8 St Lucius's Close  
Farnley Tyas

Ref:- Applications 2021/93006, 2021/93007, 2021/92969  
Yew Tree Farm, Farnley Tyas

These applications are all for Yew Tree Farm which is in the centre of the Conservation Area of Farnley Tyas.

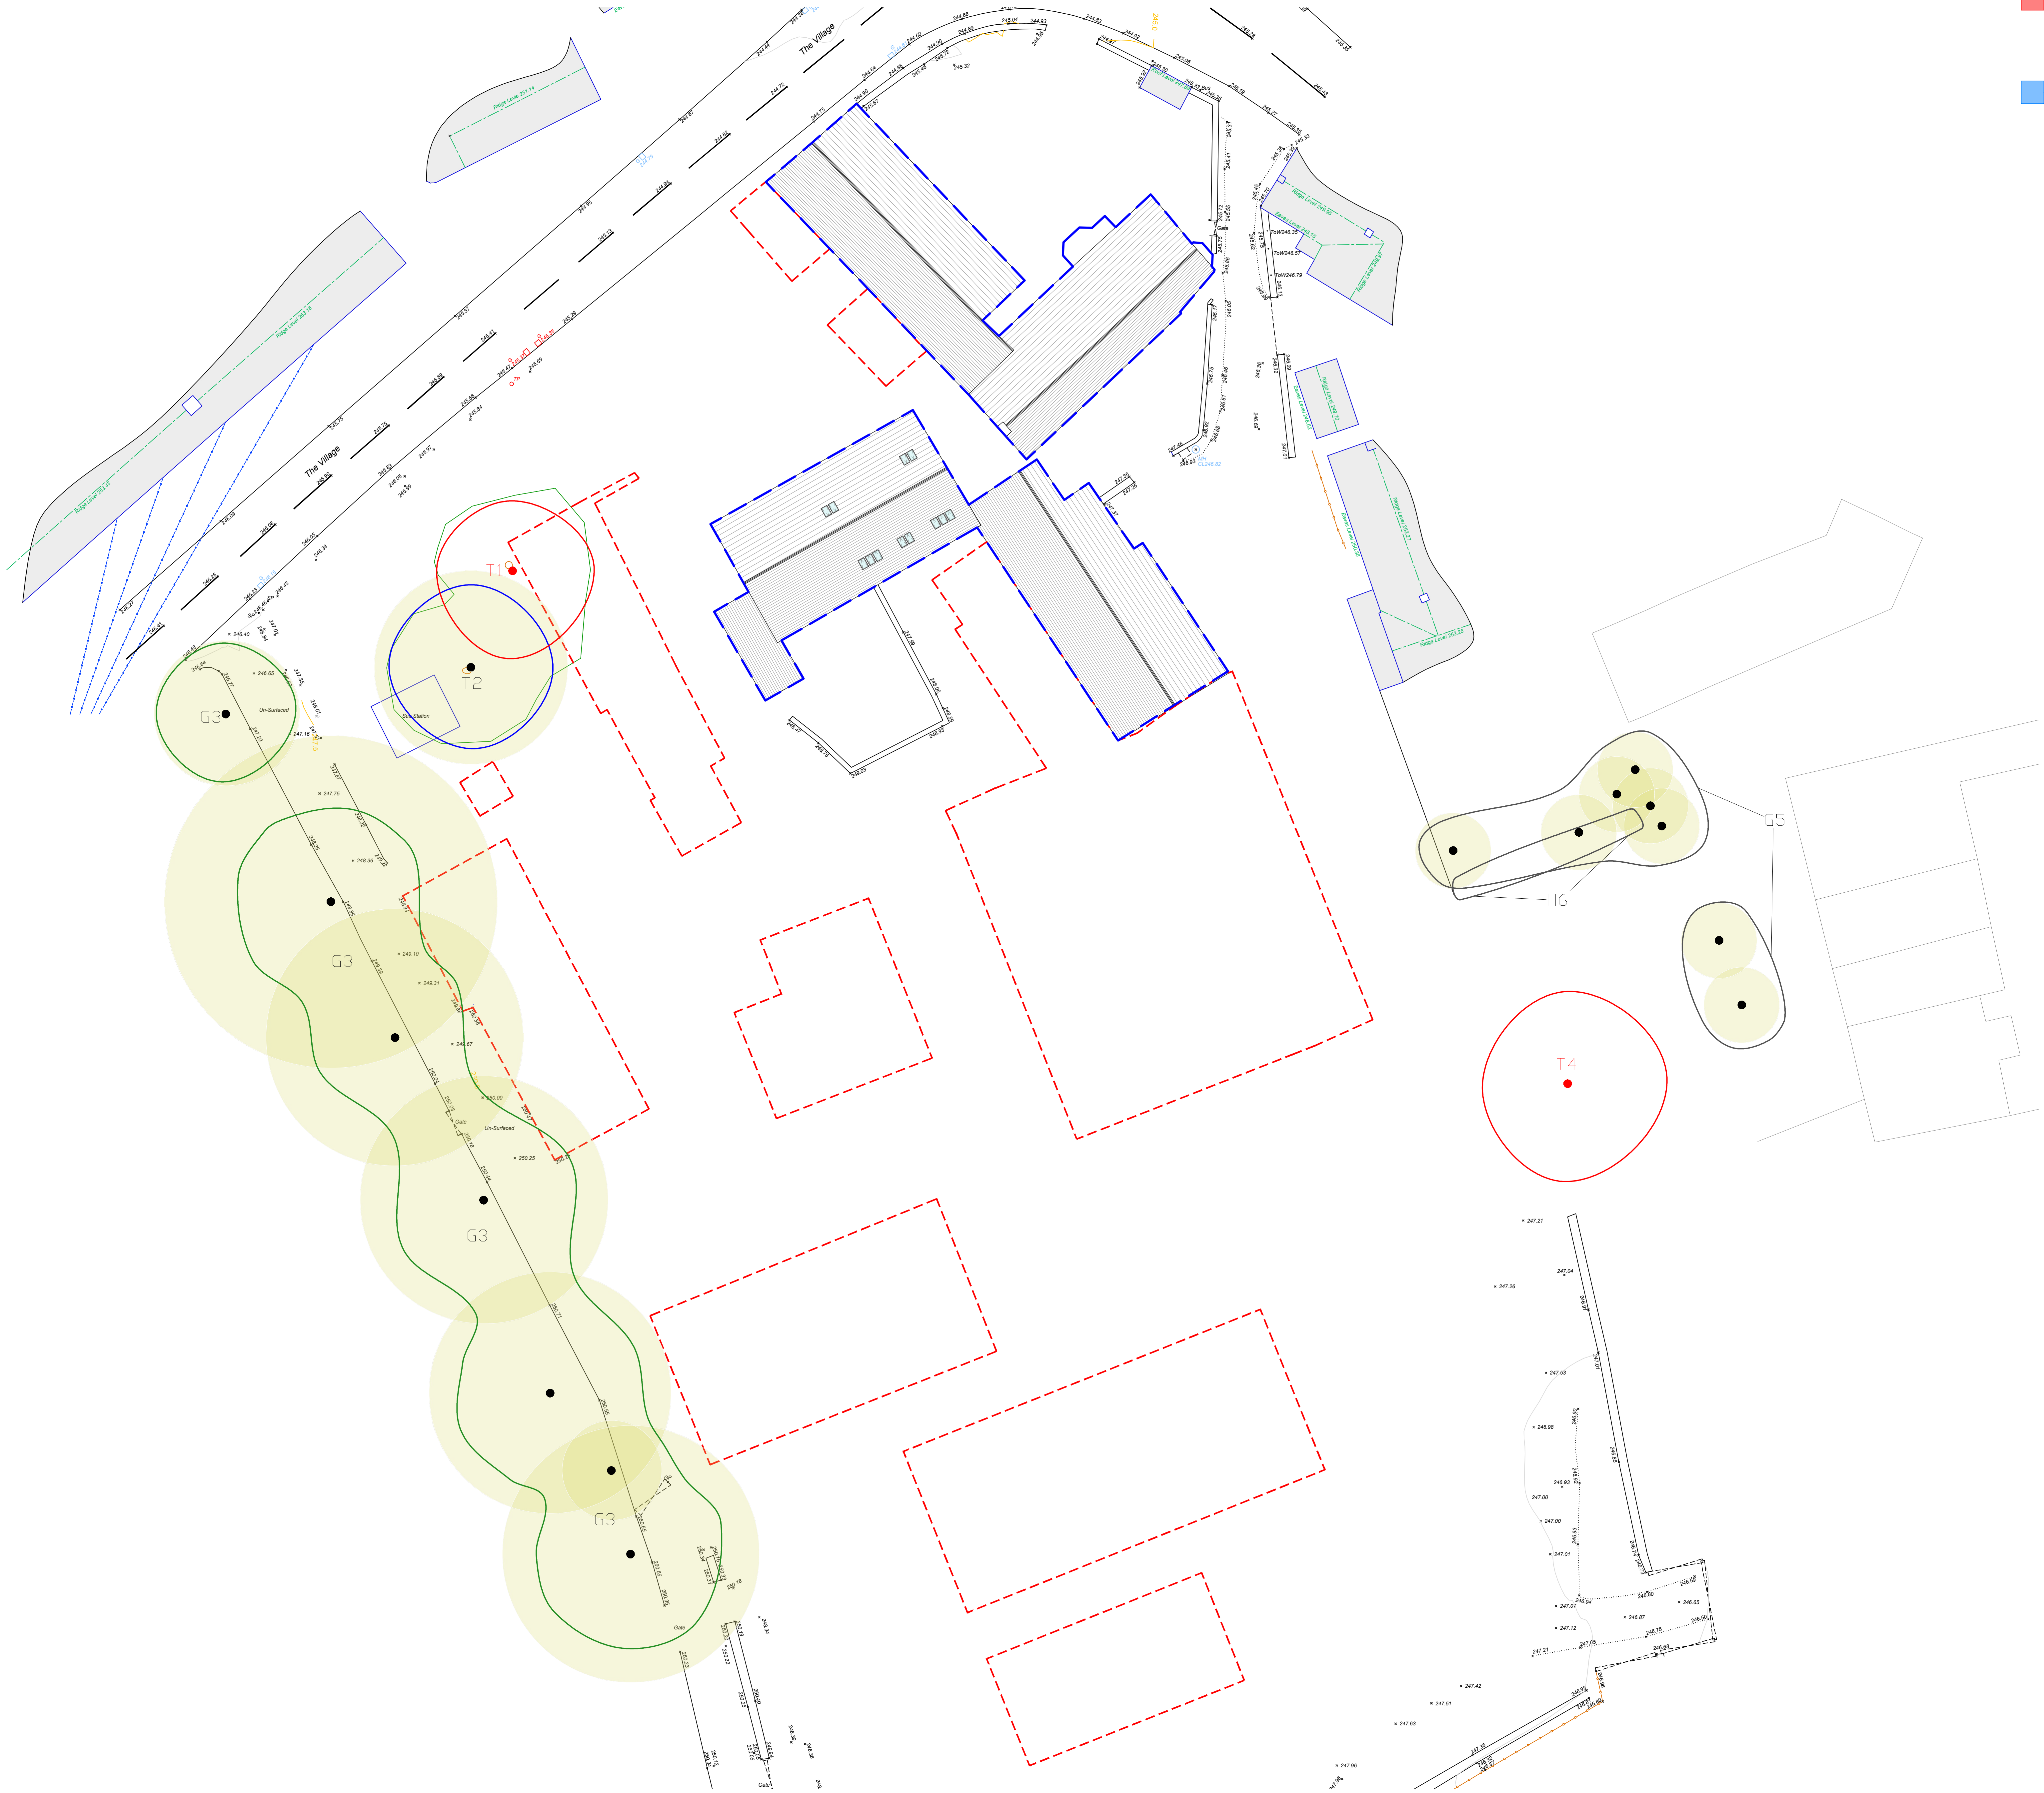
The Barn at Yew Tree Farm, Historic England listed number 1392518, is to be converted into 4 dwellings and in the plans, include 2 new openings plus the removal of 2 structures attached to the principal building.

The Historic England listing states "Any object or structure fixed to the principal building or buildings and any object or structure within the curtilage of the building, which, although not fixed to the building, forms part of the land and has done so before 1<sup>st</sup> July, 1948 is by law to be treated as part of the listed building".

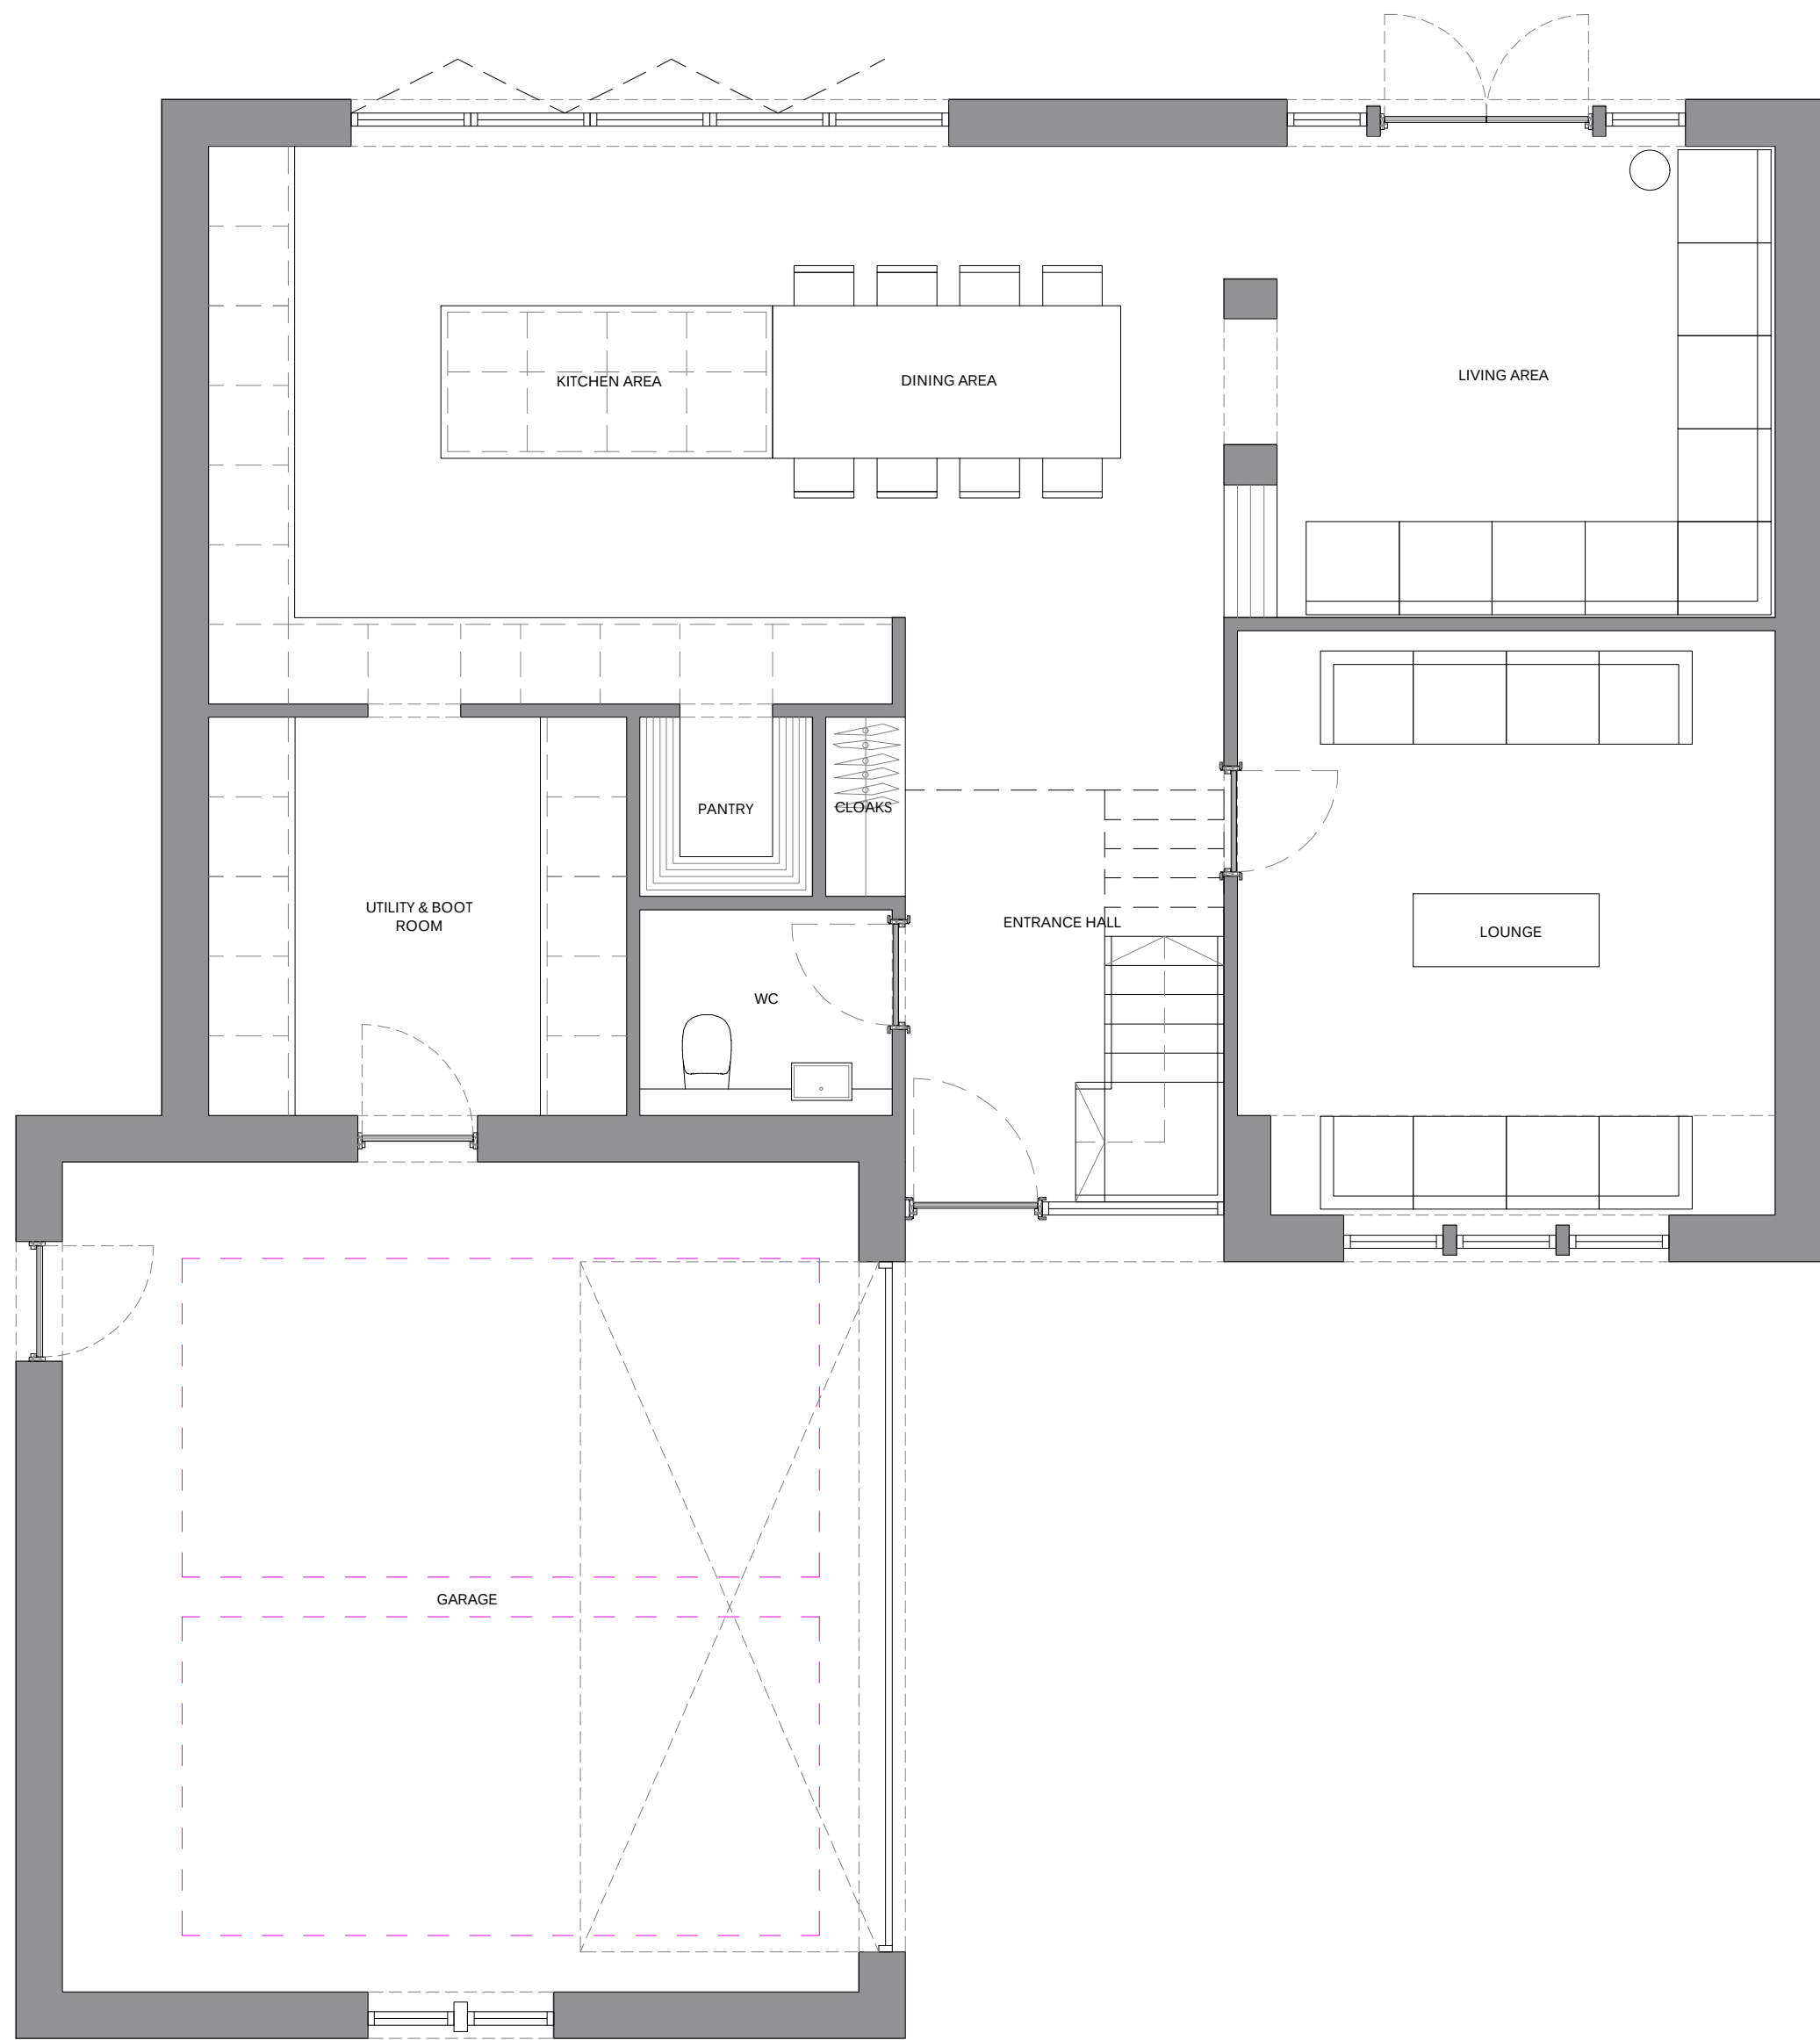
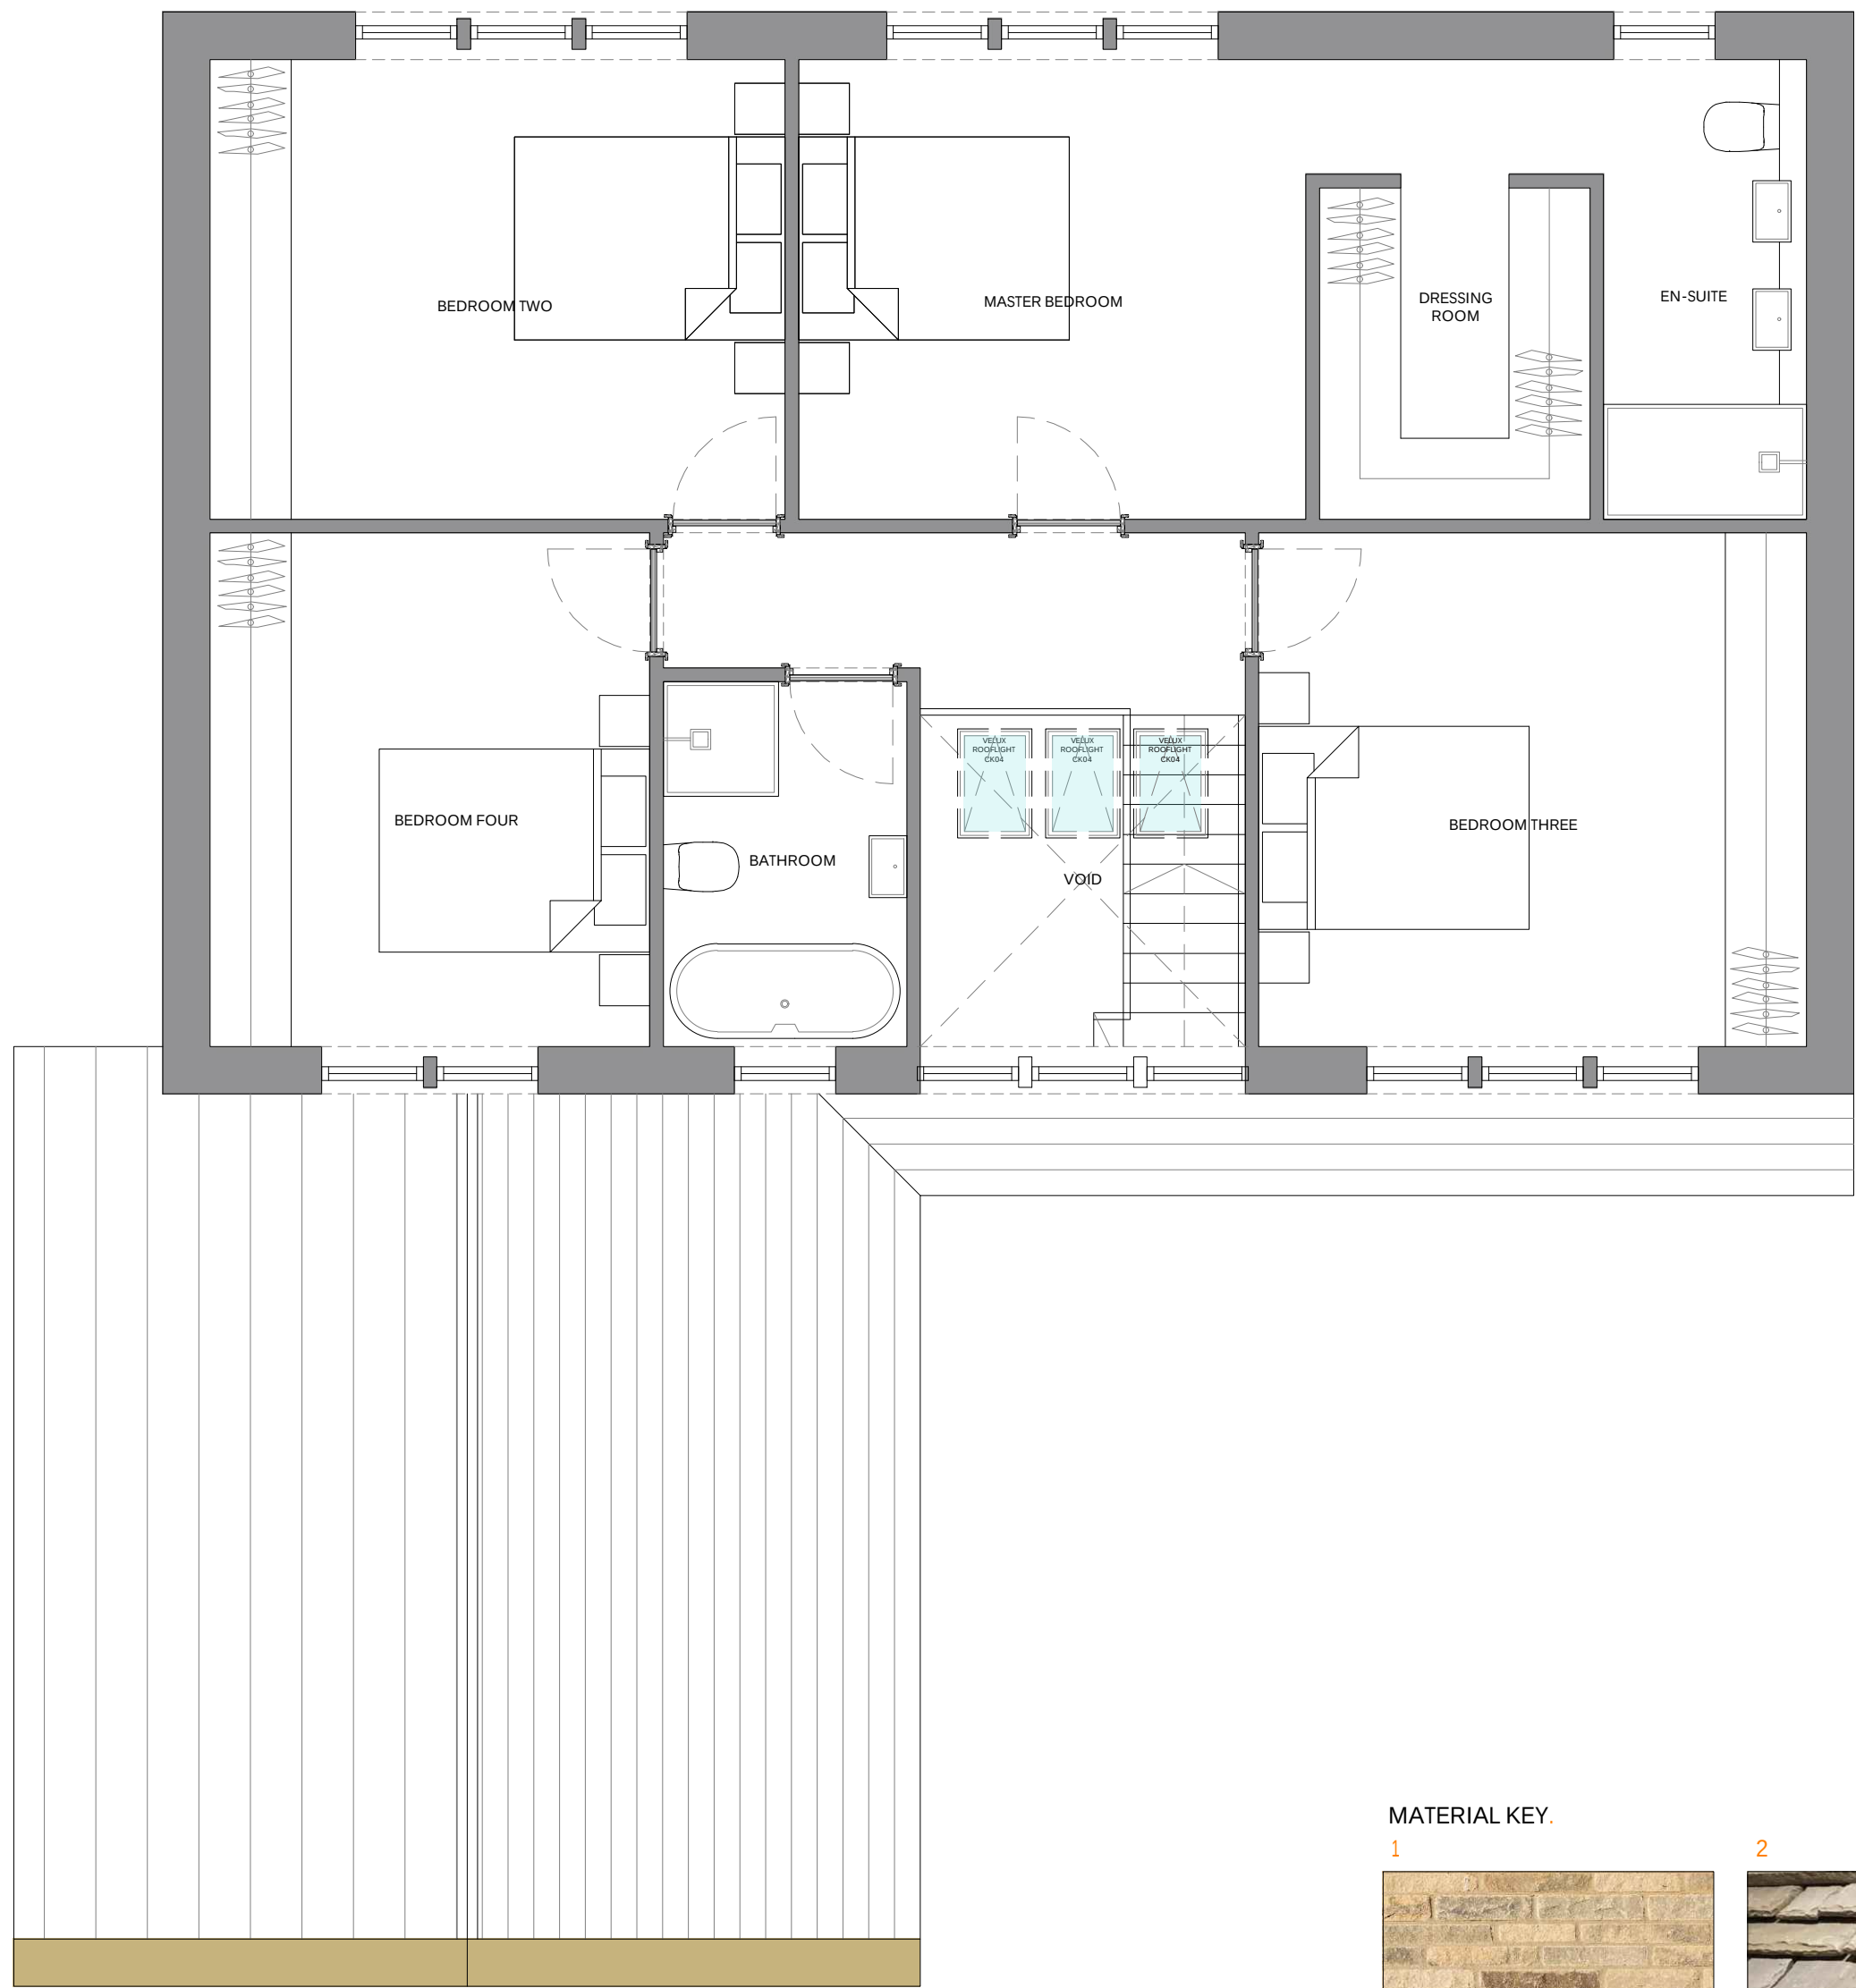
The design of any of the new builds do not reflect a Historic Farmstead and in particular the four new builds which will be viewed from entering the village from Storthes Hall. These four new builds will be considerably higher than any of the listed buildings within the site and adjacent to the site and will be detrimental to the view into a Conservation Area. The plans for these four new builds also show that the gardens are encroaching the Green Belt.

The materials stated in the plans for the new builds should be sympathetic to the listed buildings rather than the ones stated in the application.
